Your ref: TR050007  
My ref: DCO/TR050007/HinckleySRFI

16<sup>th</sup> February 2024

**TR050007 Hinckley SRFI – Warwickshire County Council (20040686 )  
Comments on Documents Requested to be Submitted by Deadline 6**

Drawing file: TR050007 / TR050007-002508-Hinckley NRFI Appendix 14 - Gibbet Hill Mitigation Swept Paths.pdf

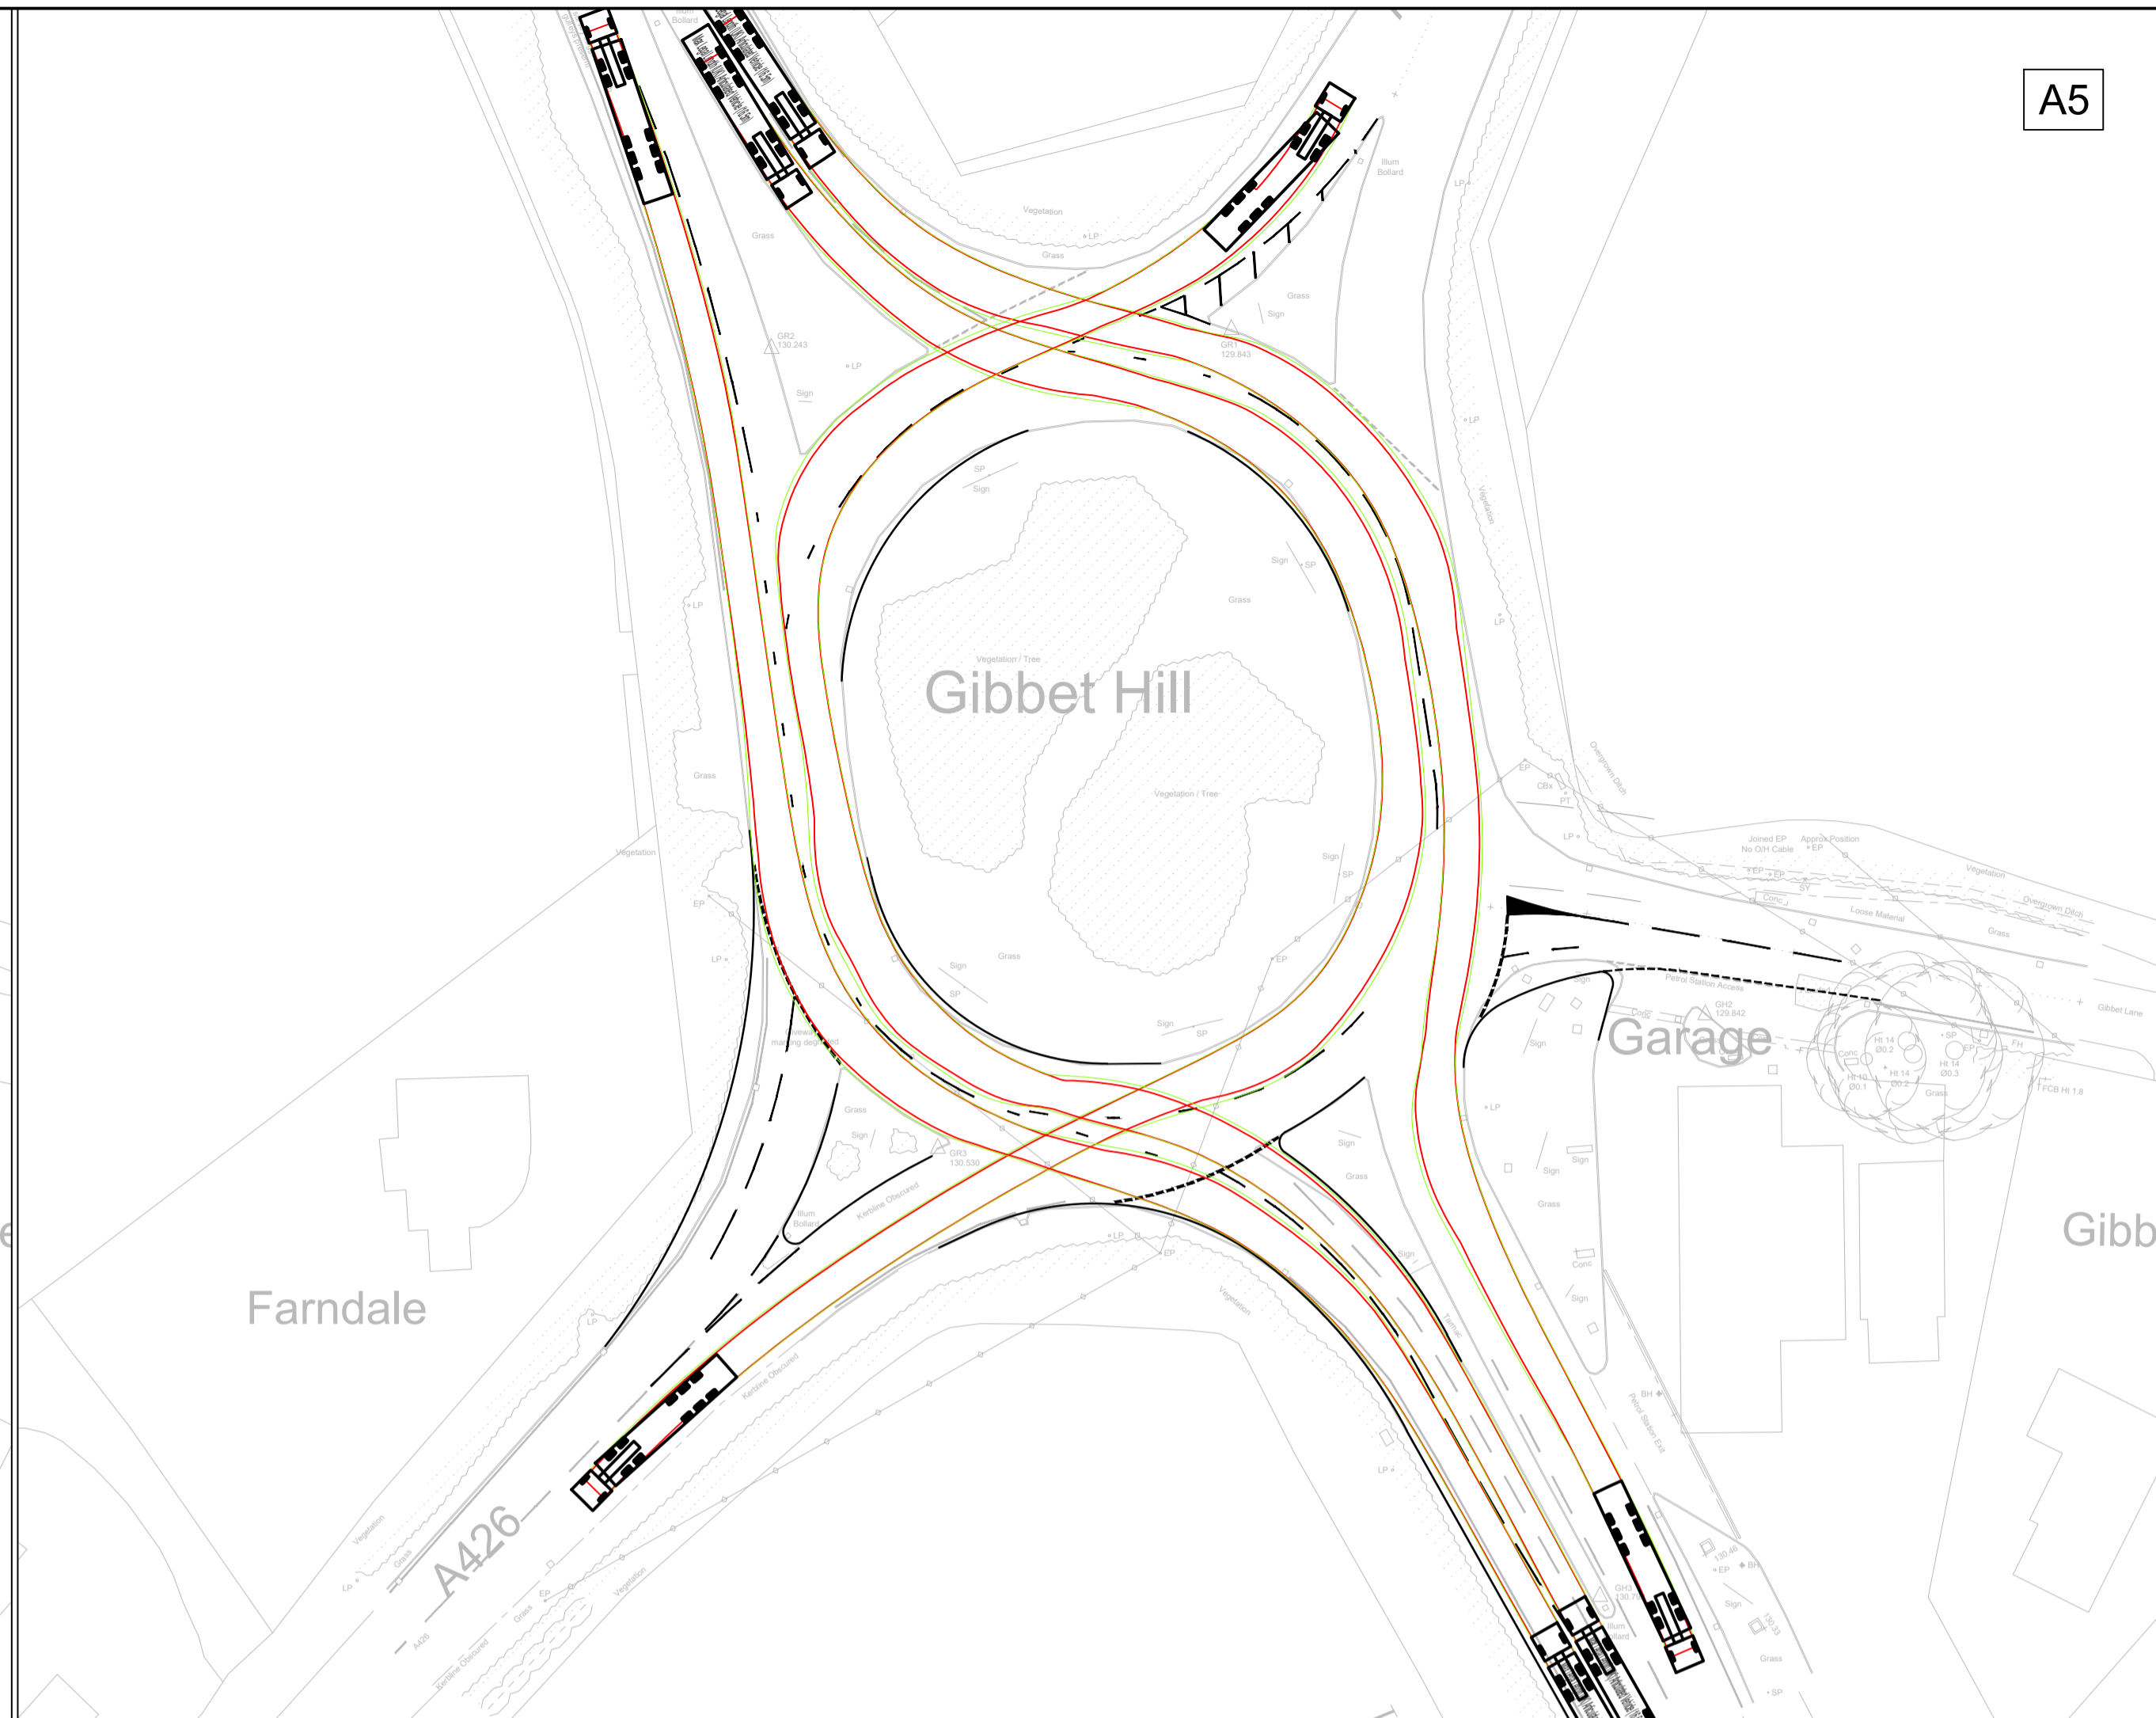
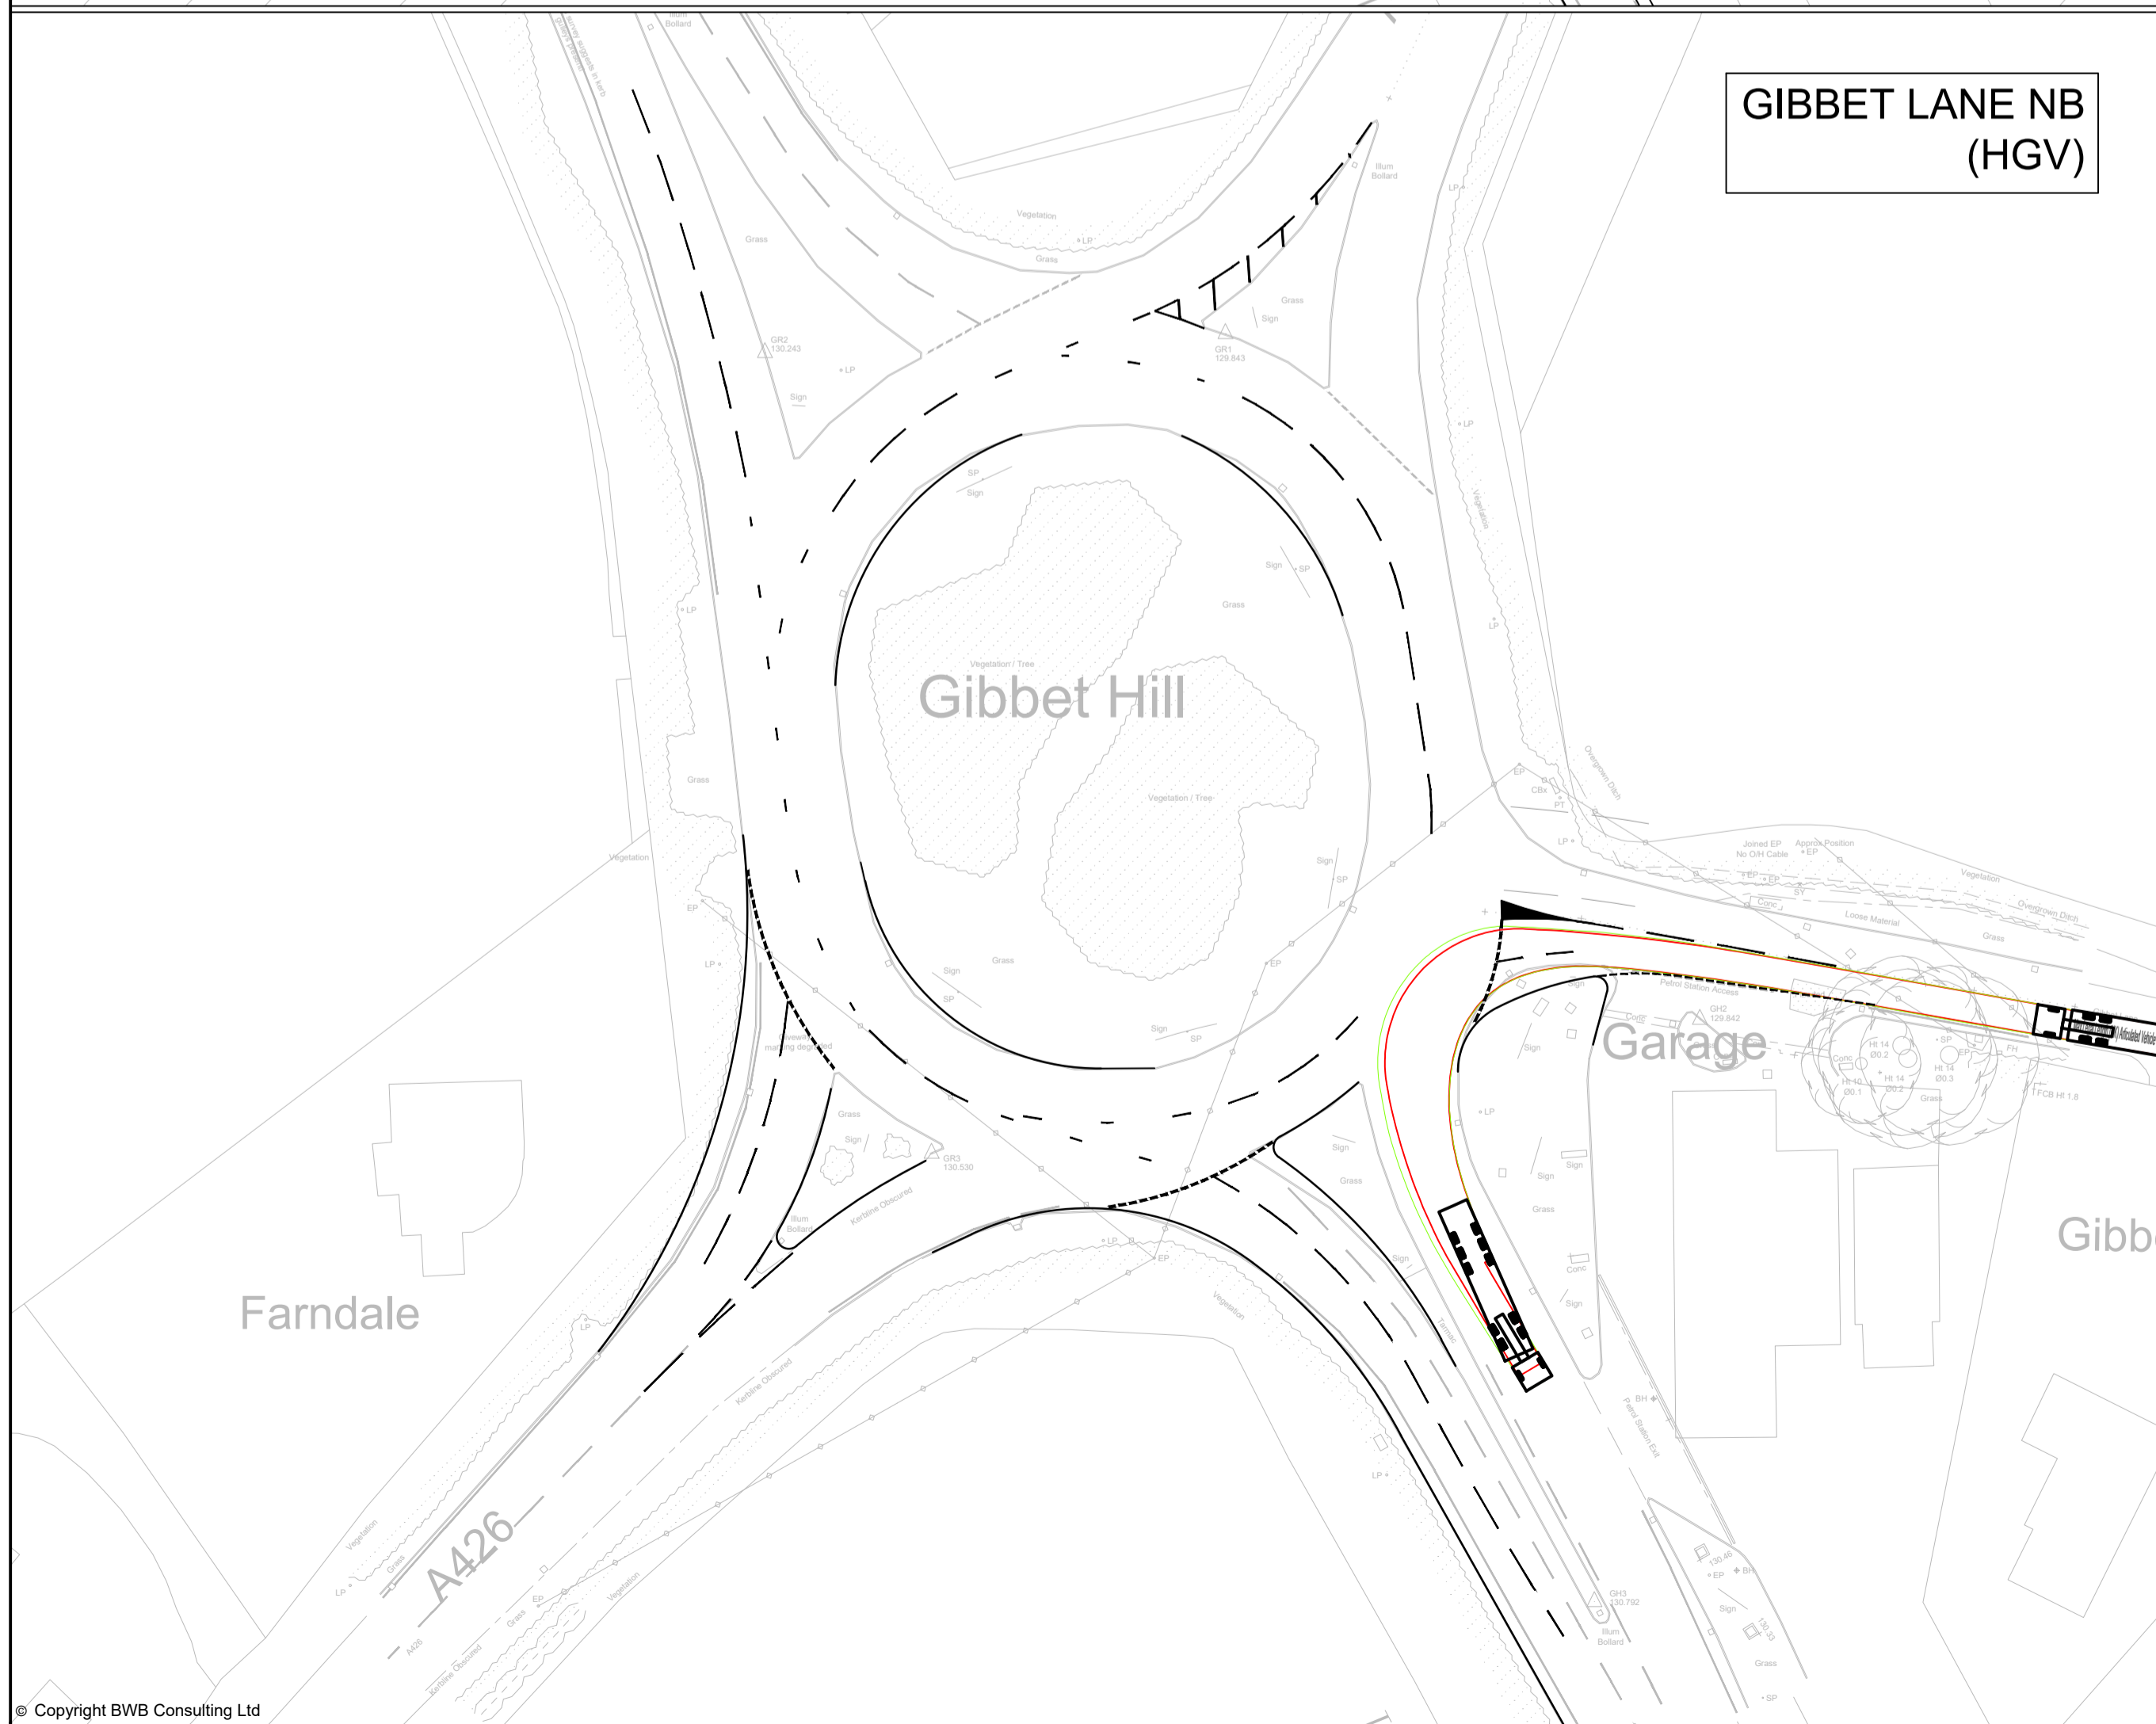
Further discussion has taken place with The Applicant and BWB over the revised turning flows following the initial furnished flows that were provided. WCC raised concerns over the level of flows forecast from Gibbet Lane in comparison to the proportion observed in the 2023 surveys. Although WCC noted that the A5 south to A426 south movement had increased, it was considered that this could be due to other committed development traffic growth, however it is understood that National Highways also raised concerns. This was set out in our Deadline 5 response.

BWB have carried out a sensitivity assessment and utilised the 2023 observed entry proportions to derive adjusted flows for the 2036 scenarios. WCC has reviewed the flows and consider that they represent a more likely pattern of flows at the junction.

Whilst the adjusted flows have been used to carry out sensitivity tests for the capacity performance at the junction using ARCADY. WCC do not consider that the 2023 scenarios adequately reflect the current junction performance in the peak hours and therefore cannot be relied upon to identify the degree of impact that the development traffic is likely to have in a 2036 scenario.

WCC still consider that the use of the VISSIM model is the best available tool to use to identify the impacts of the forecast development traffic on what is an already congested part of the network, as set out in our earlier responses.
